RE: 1635 Harrington Road
Broadway, NC

Per your request, the garage under construction at the above referenced address has been analyzed in the areas we discussed.

1635 Harrington Rd.
Shelter and Storage

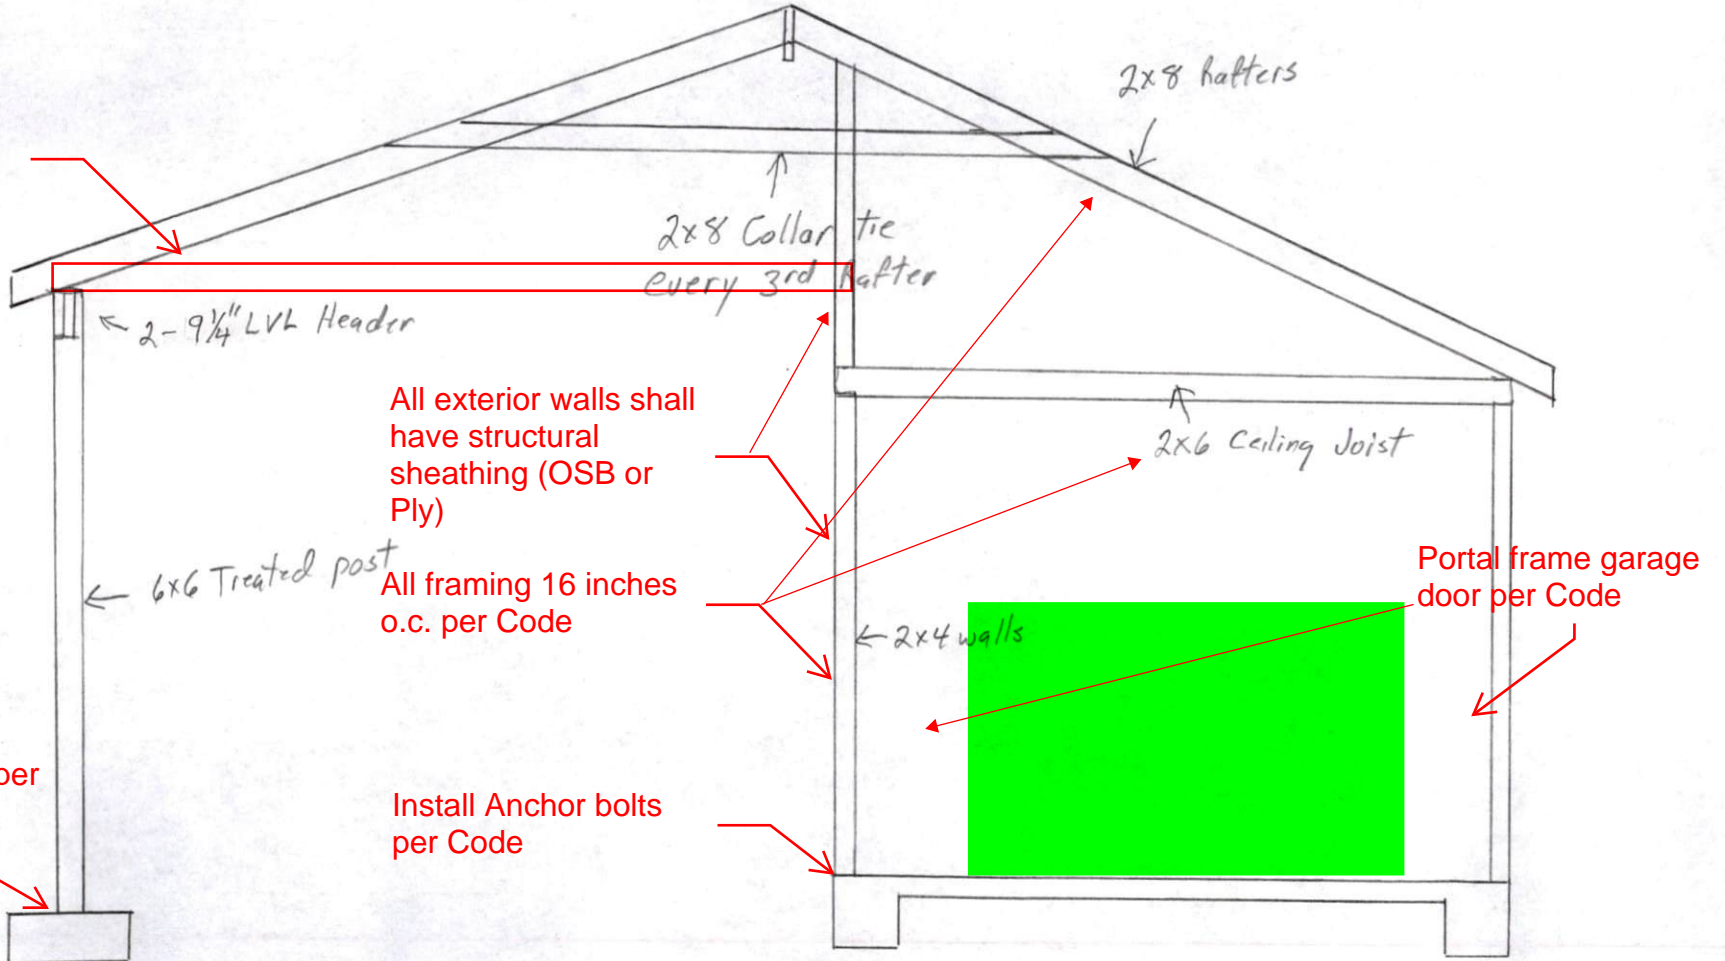
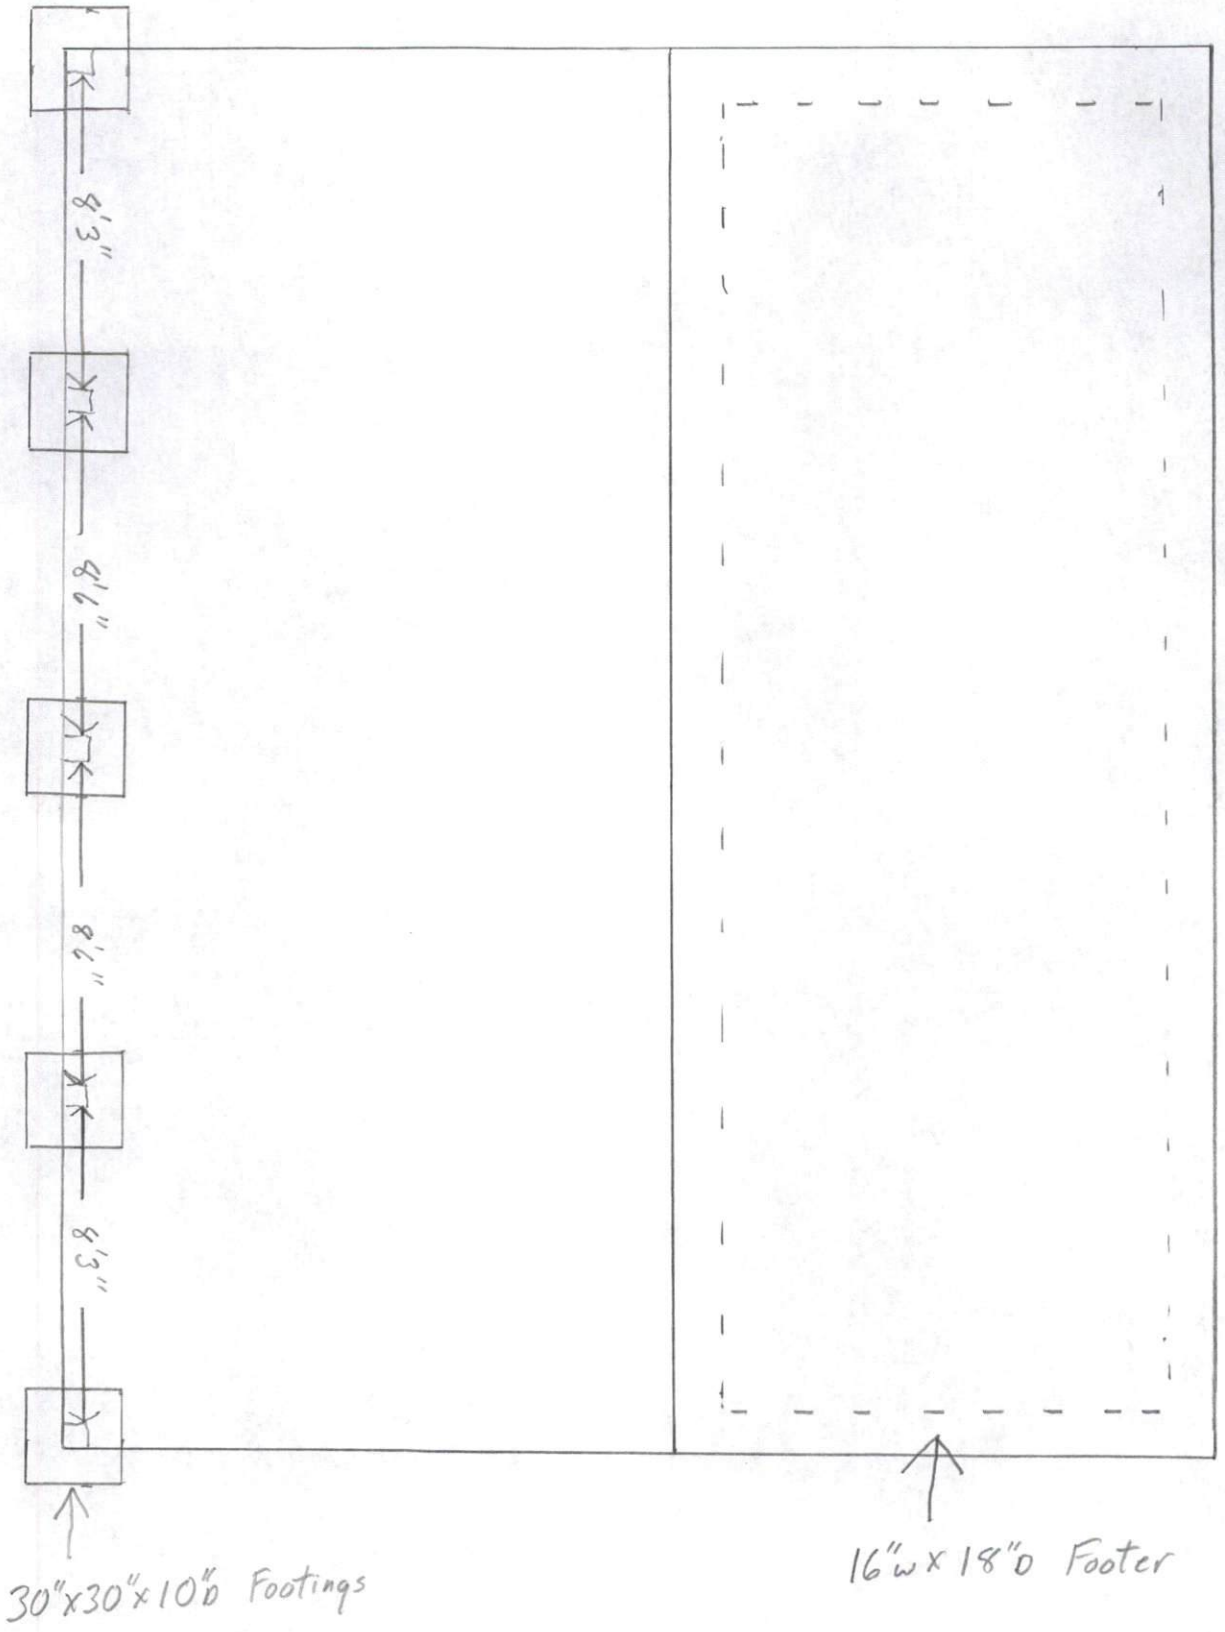
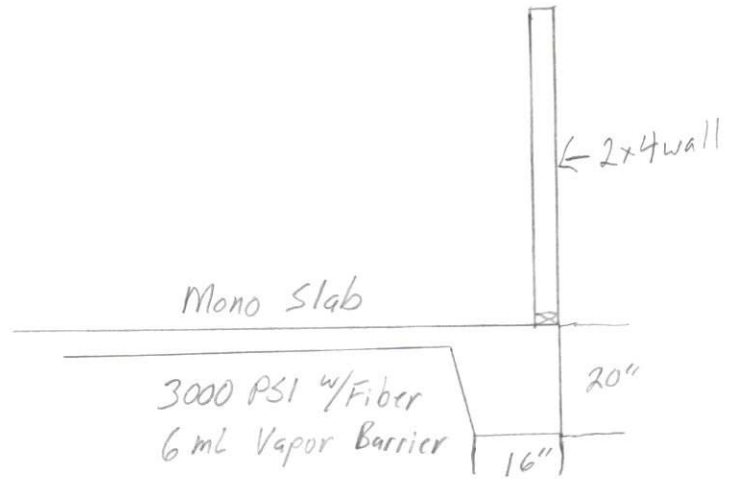
- 1) Every other 2 x 6 ceiling joist is required to be doubled (32" o.c.) due to the span and storage area above the garage.
- 2) The (2) 2 x 10 continuous garage door header spanning corner to corner with (2) 2 x 4 under each end and (2) 2 x 4 at each side of the door opening is properly sized and supported. One 36" long coil strap attached with one 8d nail 3" o.c. is required at each support. King studs are not required at each end of the header since the header abuts the perpendicular walls of the garage.
- 3) 2 x 4 collar ties are to be installed in the upper third of the rafters 32" o.c. attached at each end with a minimum of (3) 12d nails.

With the above noted modifications to the areas noted, these areas are properly sized and constructed to provide the required support for all applied loads.
